**The Old Post Office
Main Street
Sibford Ferris
Banbury
OX15 5RG**

17/02372/F

Proposal: Erection of second storey extension to an existing single storey utility room with the renovation of the current rear ancillary buildings.

Proposed First Floor Plan
170182 - A - RF - 120

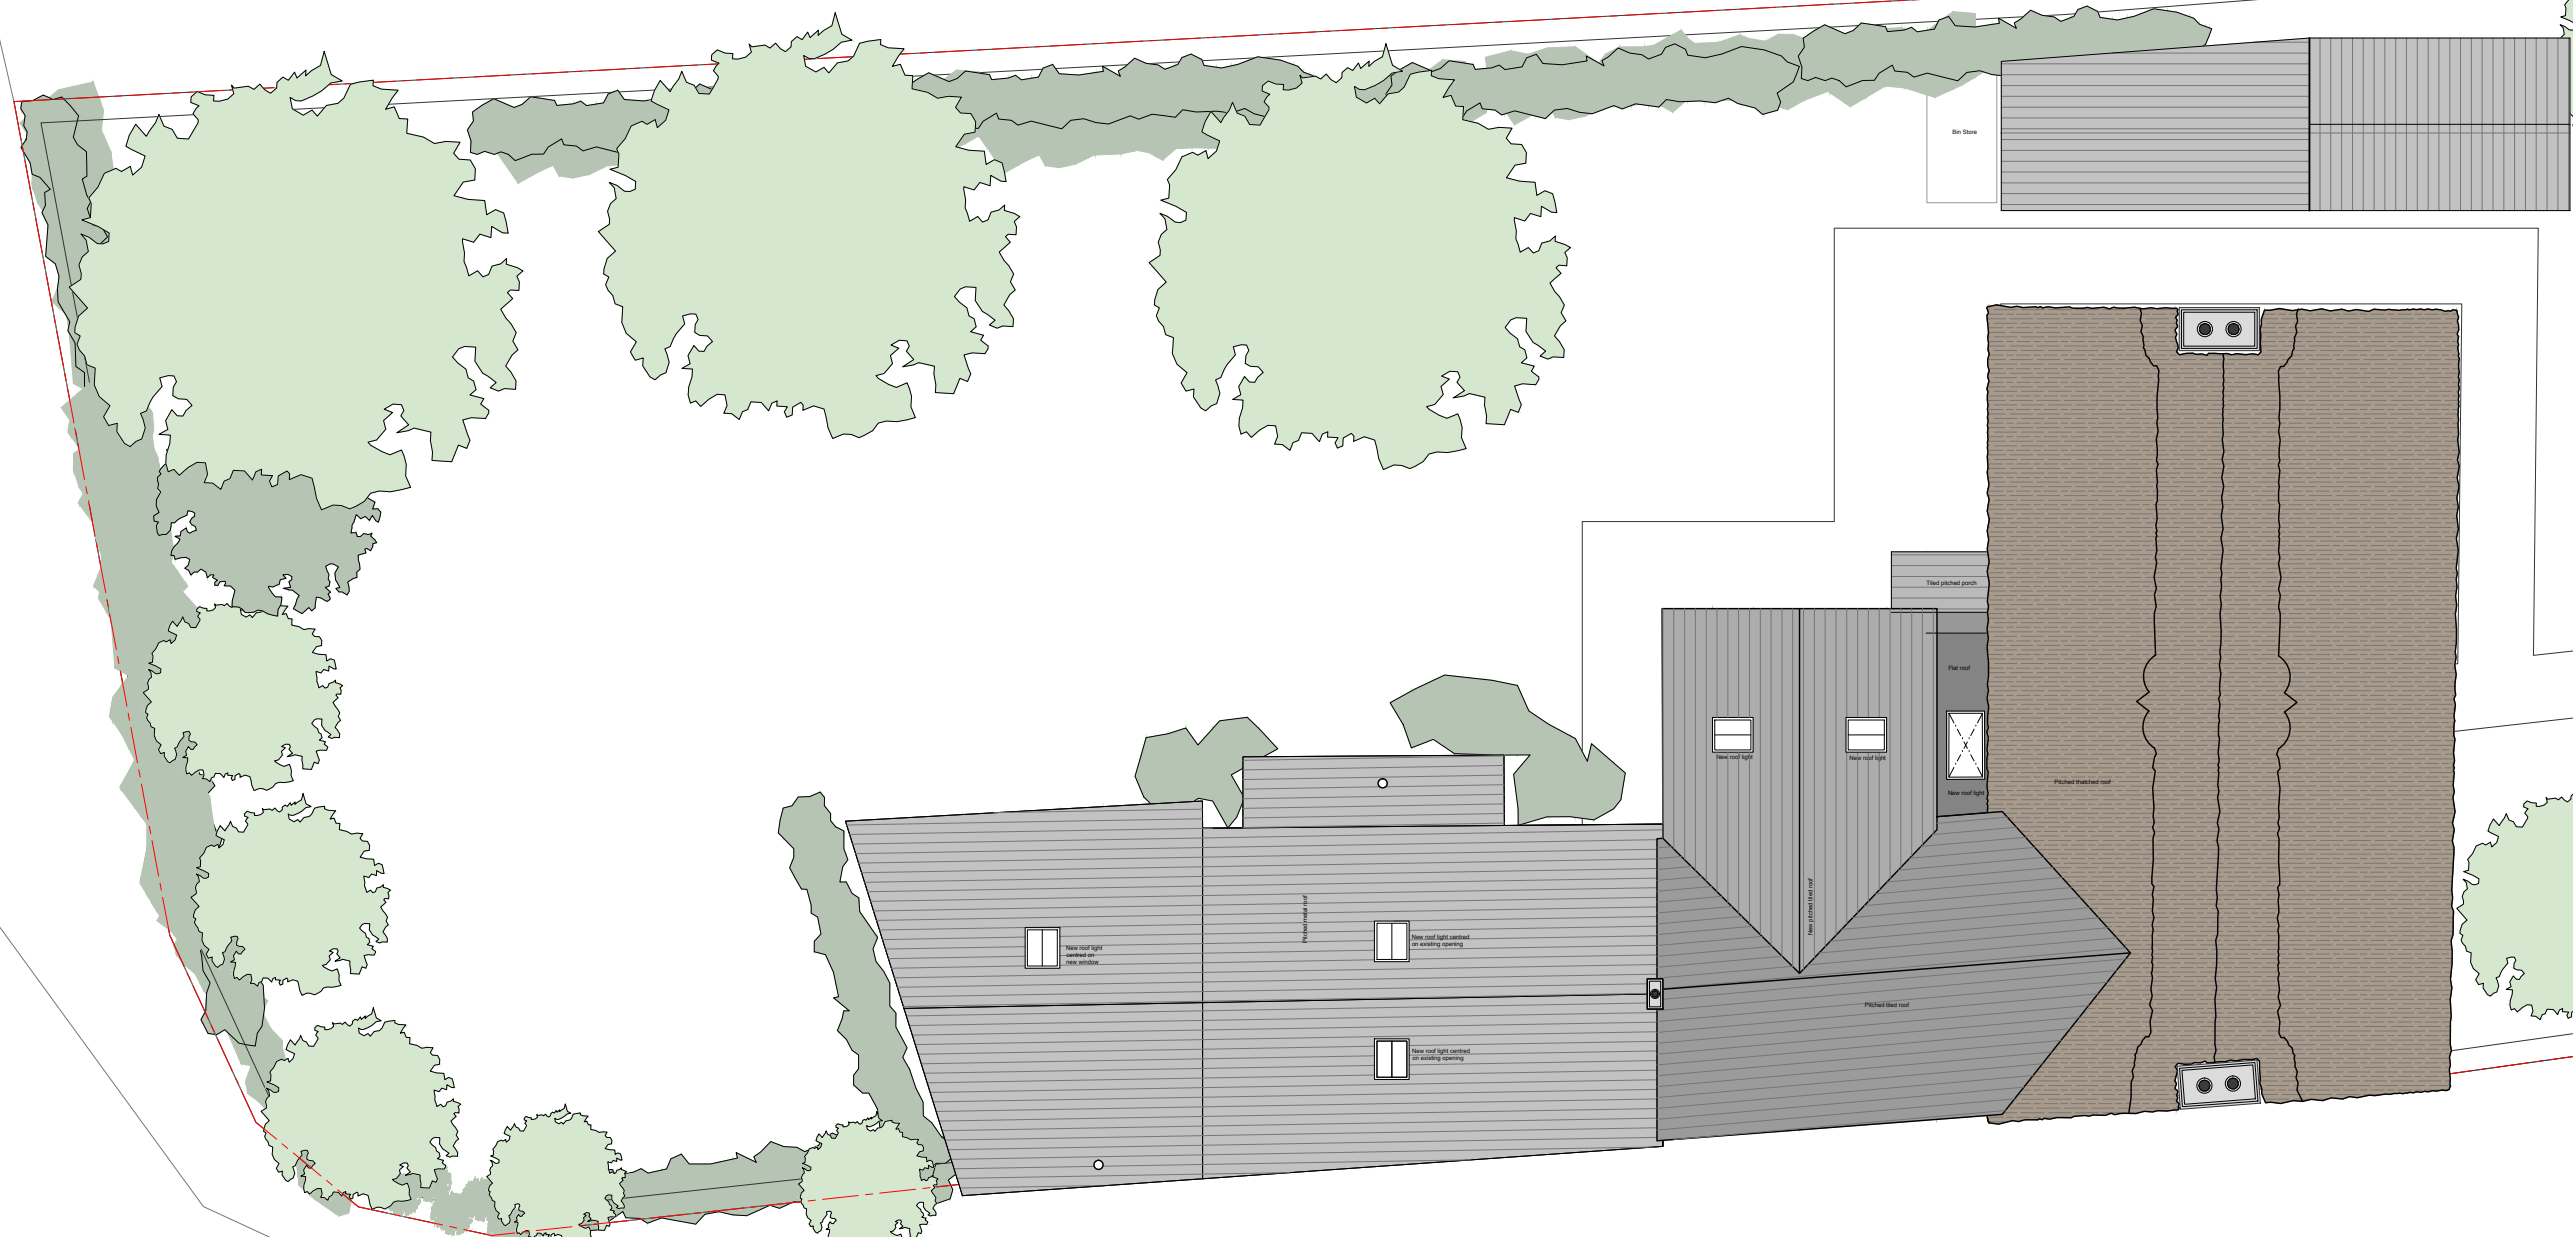
“The existing and proposed plans show the removal of a partition between bedroom 3 and 4. At the site visit on 15th January the partition was no longer in existence. The configuration of the partition as shown on ‘existing’ plans indicate that it was of modern origin. It is clear, however, that there was an earlier partition in this location as there is a slot cut into the underside of the beam. The ceiling has also been removed in this area and this is highly unlikely to have been a historic alteration. No information is provided within the application about when this work may have been undertaken.”

170182 - A - Ex - 101

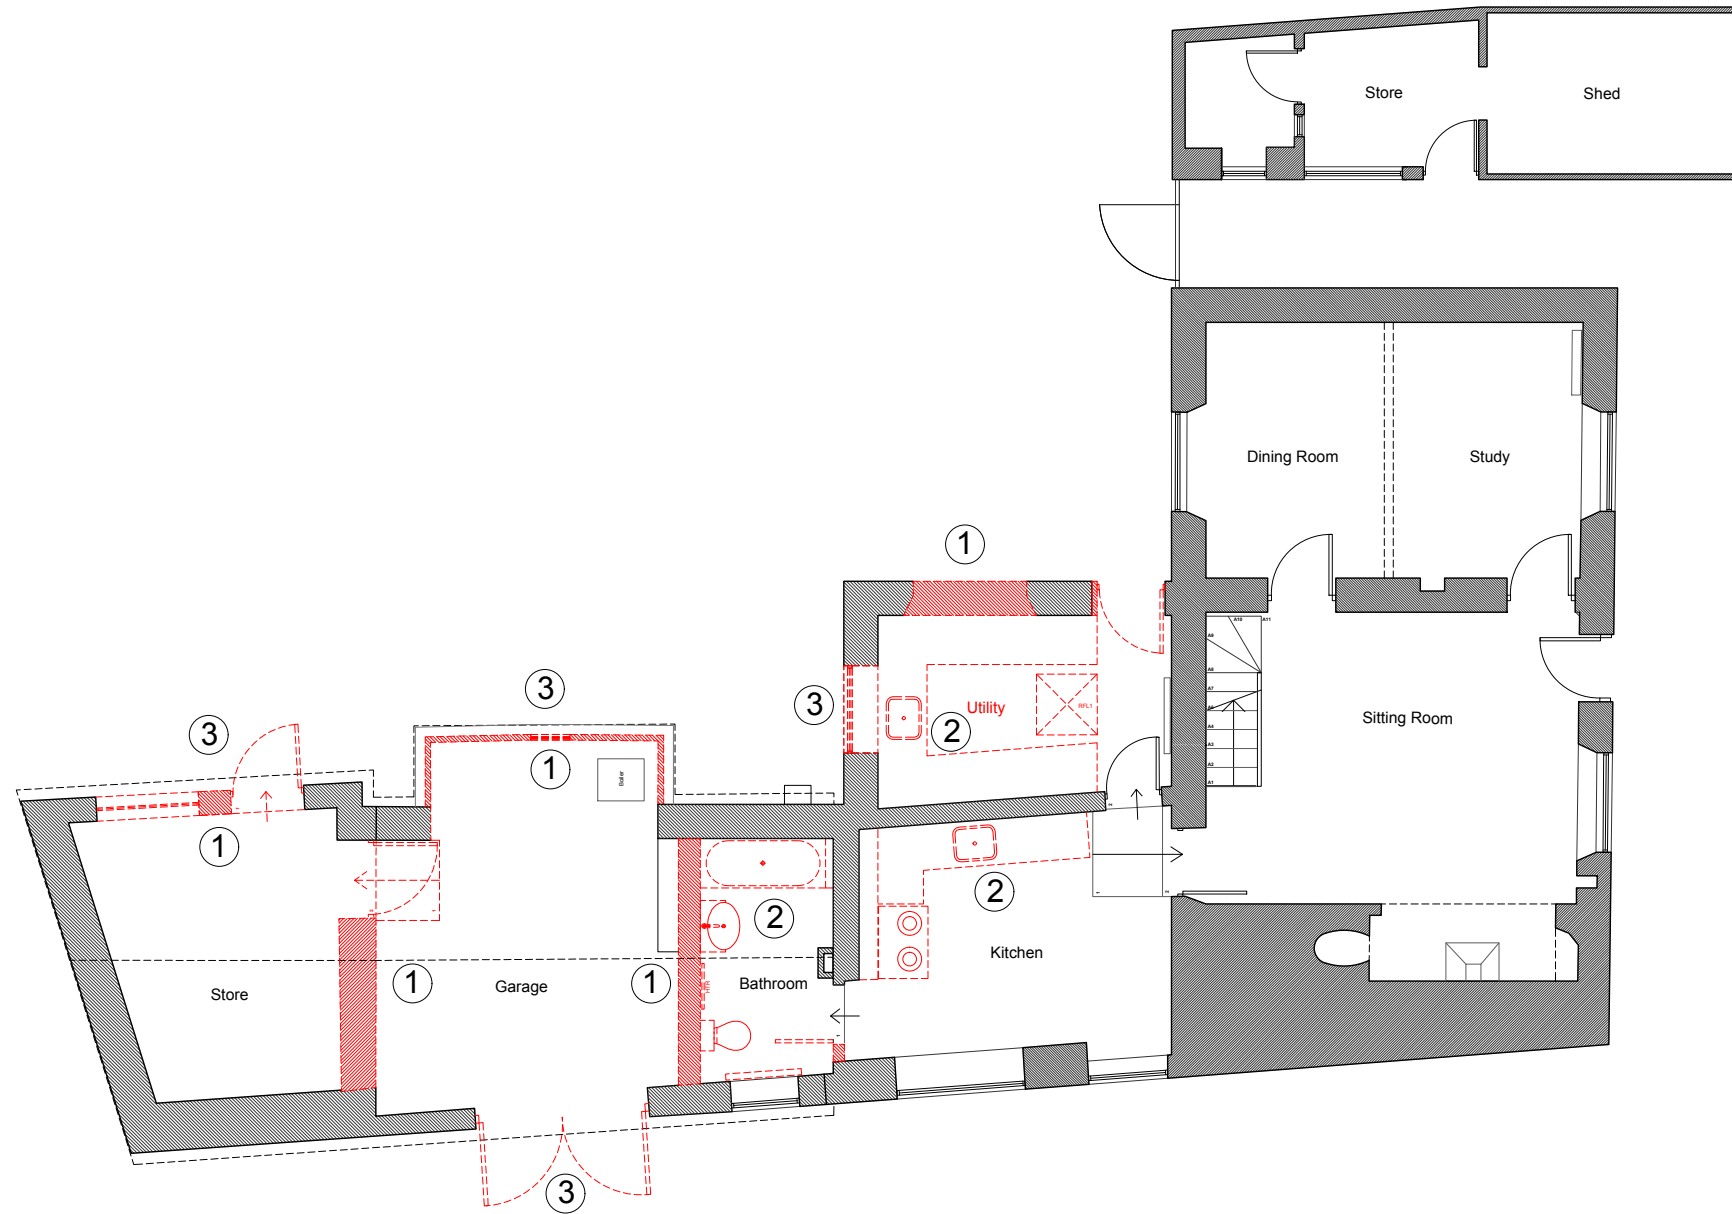
“There is, however, one concern which is with the proposed complete loss of the wall dividing the existing store and garage. This is an historic stone wall, marking the existing ‘store’ as an entirely separate structure to the existing garage. There has already been a breach through the wall to provide a doorway and there are no objections to widening this, but a section of the wall should be retained to show the historic plan form.
